**TRAIL RIDERS
FELLOWSHIP**

13th August 2018

**A303 Stonehenge; Amesbury to Berwick Down
Proposed application for development consent order
Planning Act 2008, section 48
Infrastructure Planning (Applications: Prescribed Forms and Procedure)
Regulations 2009, Regulation 4**

Supplementary consultation response of the Trail Riders' Fellowship

EXISTING A303 STOPPED UP, NO CHANGE TO BYWAY AMES 12

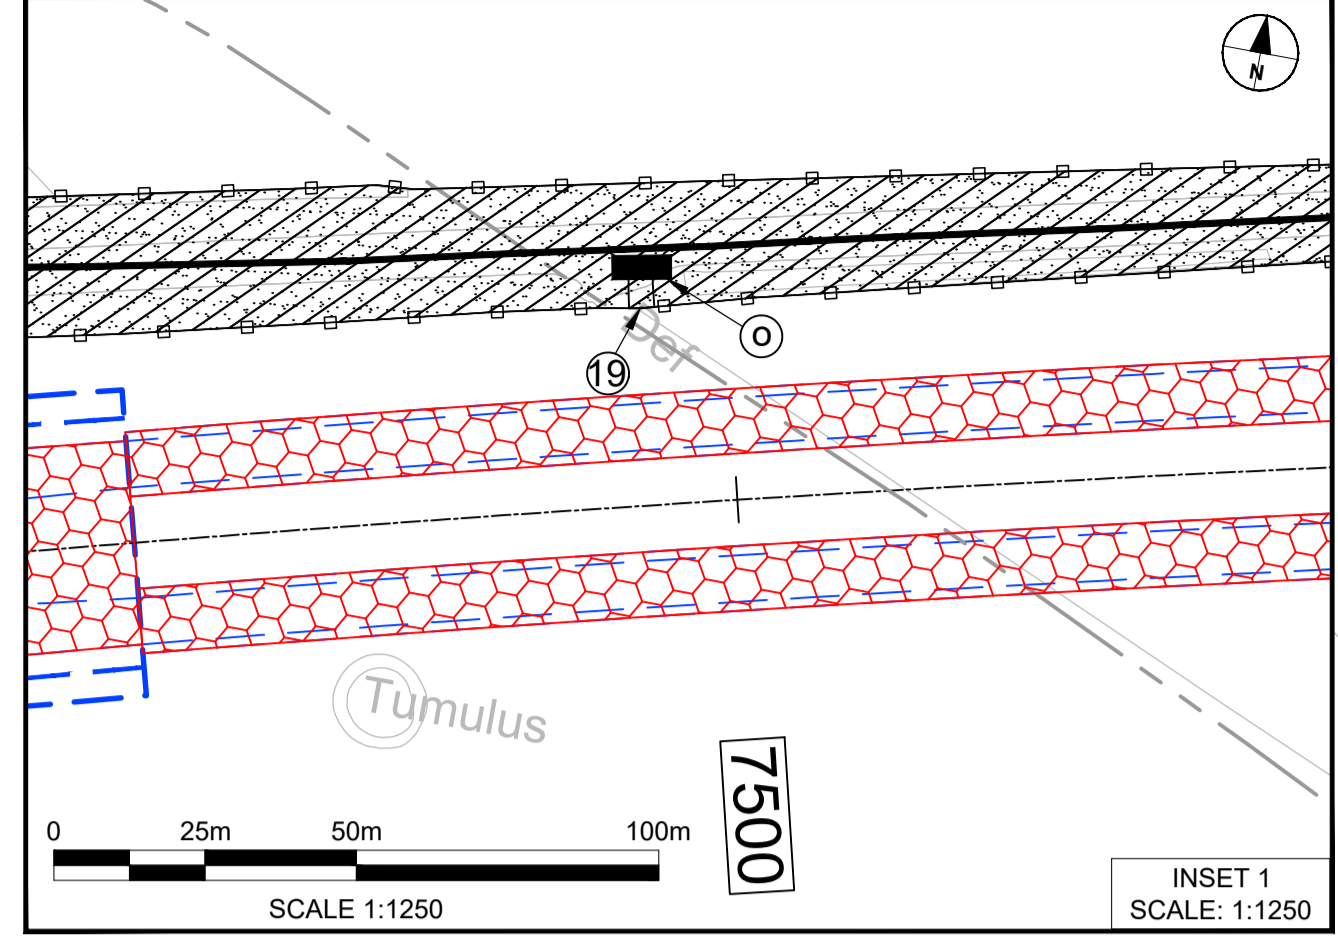
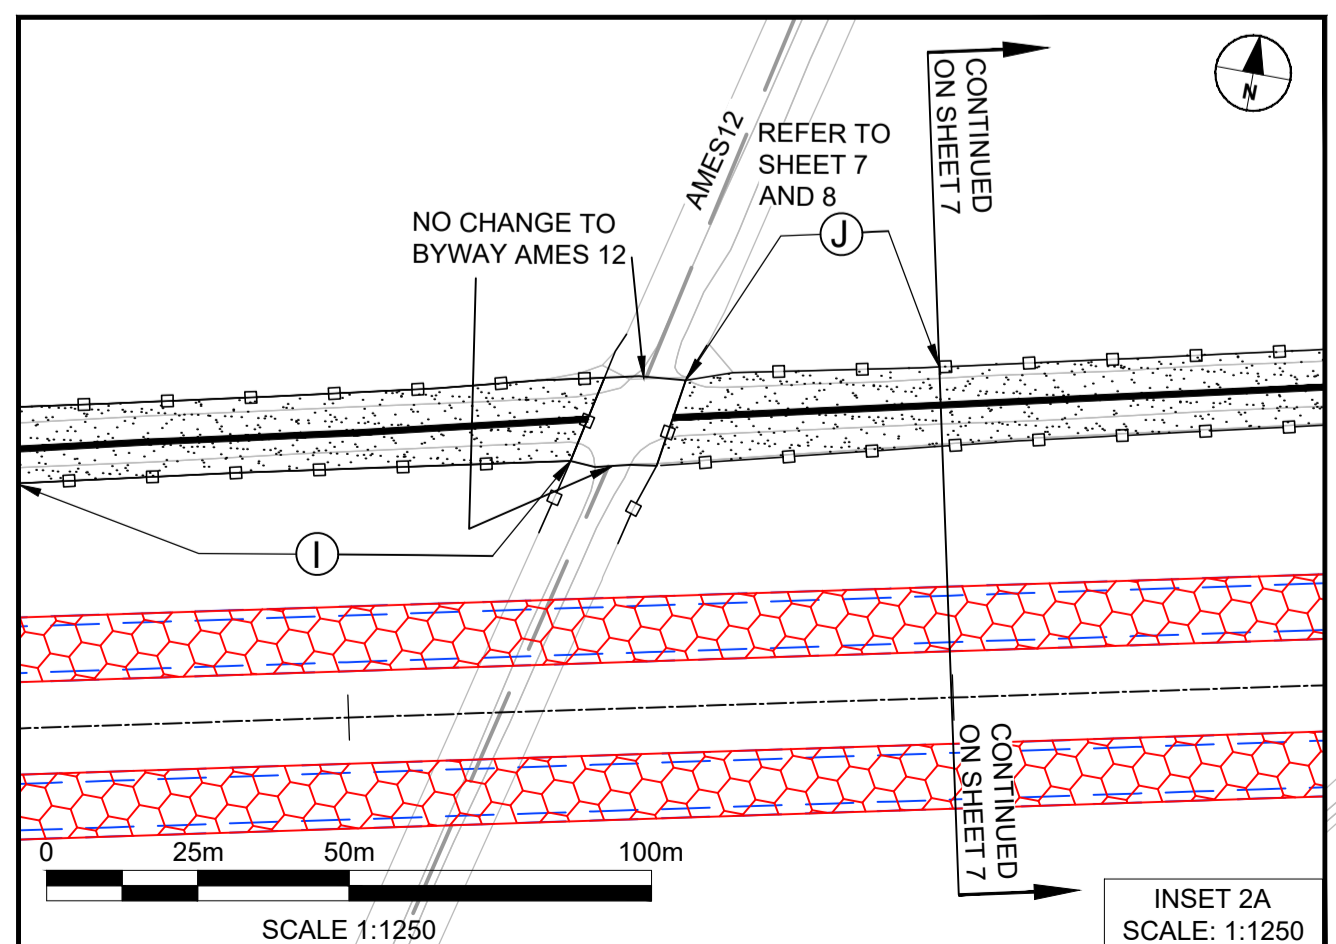
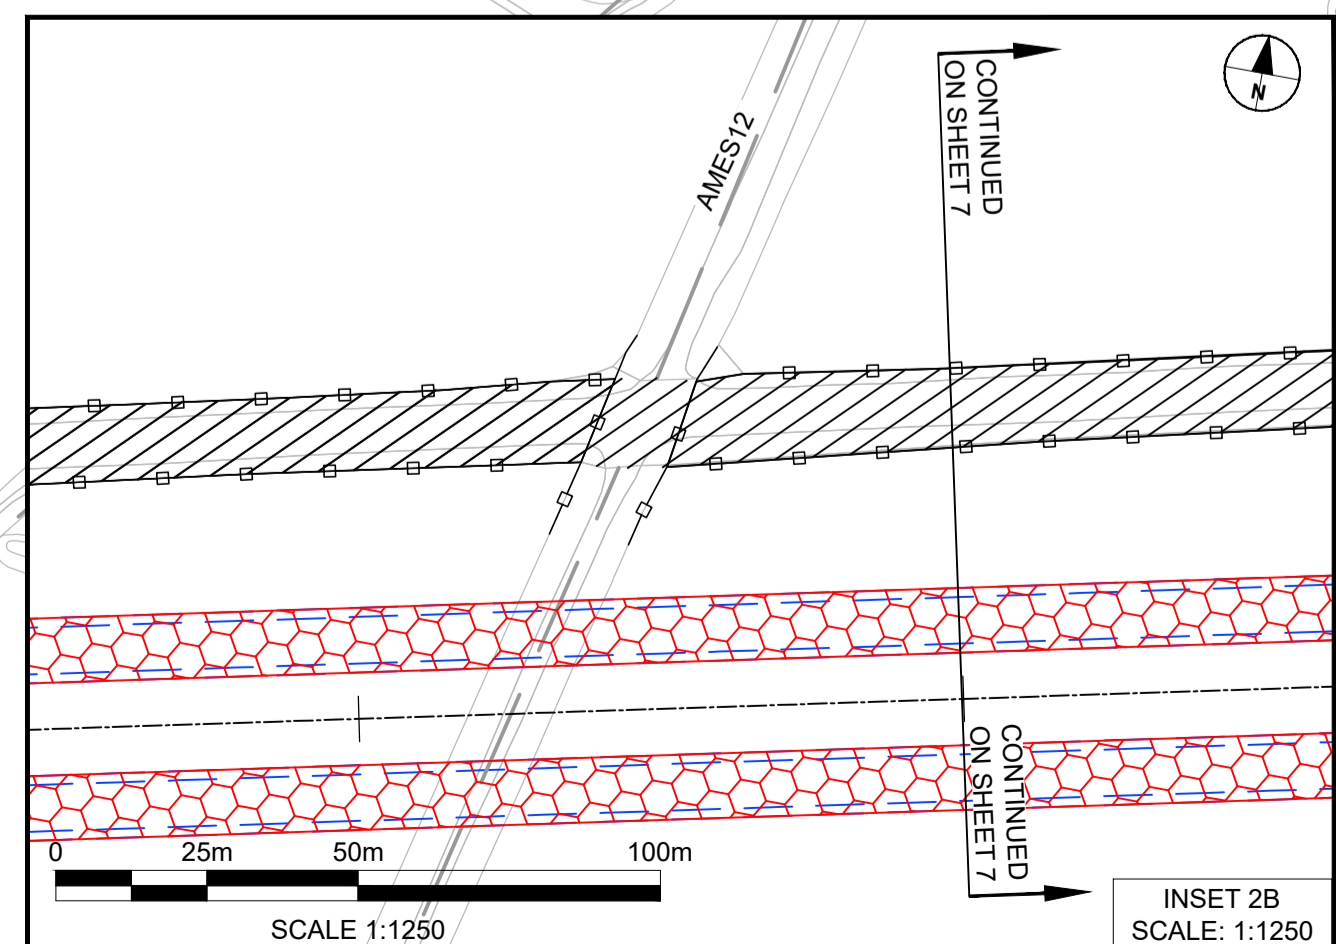
3. However, TRF is particularly concerned about, and objects to, the revised proposals for byways 11 and 12.
4. The specific proposal on page 2 of the *Supplementary Consultation Booklet* is:
“To remove the previously proposed link between Byways 11 and 12 in the Stonehenge World Heritage Site (see page 12 for more details).”

5. Page 12 sets out this proposal in greater detail:
“Removing the previously proposed link between Byways 11 and 12” and says in particular, “Following further consideration, we are no longer proposing this new link or stopping up part of Byway 11. The plans opposite show the change. The change means that motor vehicles will no longer be able to travel between Byways 11 and 12 because motorised access will be removed along the existing A303 when the tunnel is constructed. Non-motorised users will still have access between Byways 11 and 12 via the proposed new restricted byway along the line of the existing A303.”

11. Highways England’s proposals extinguish the historic connection between byways 11 and 12, leaving byway 11 in particular as a dead-end. In TRF’s submission, as is amply demonstrated by the 2005 and 2011 inquiries, byways 11 and 12 *are* very clearly required for public use. The revised proposals however do not provide an alternative. It does not appear from the *Supplementary Consultation Booklet* that Highways England has given any consideration to this.
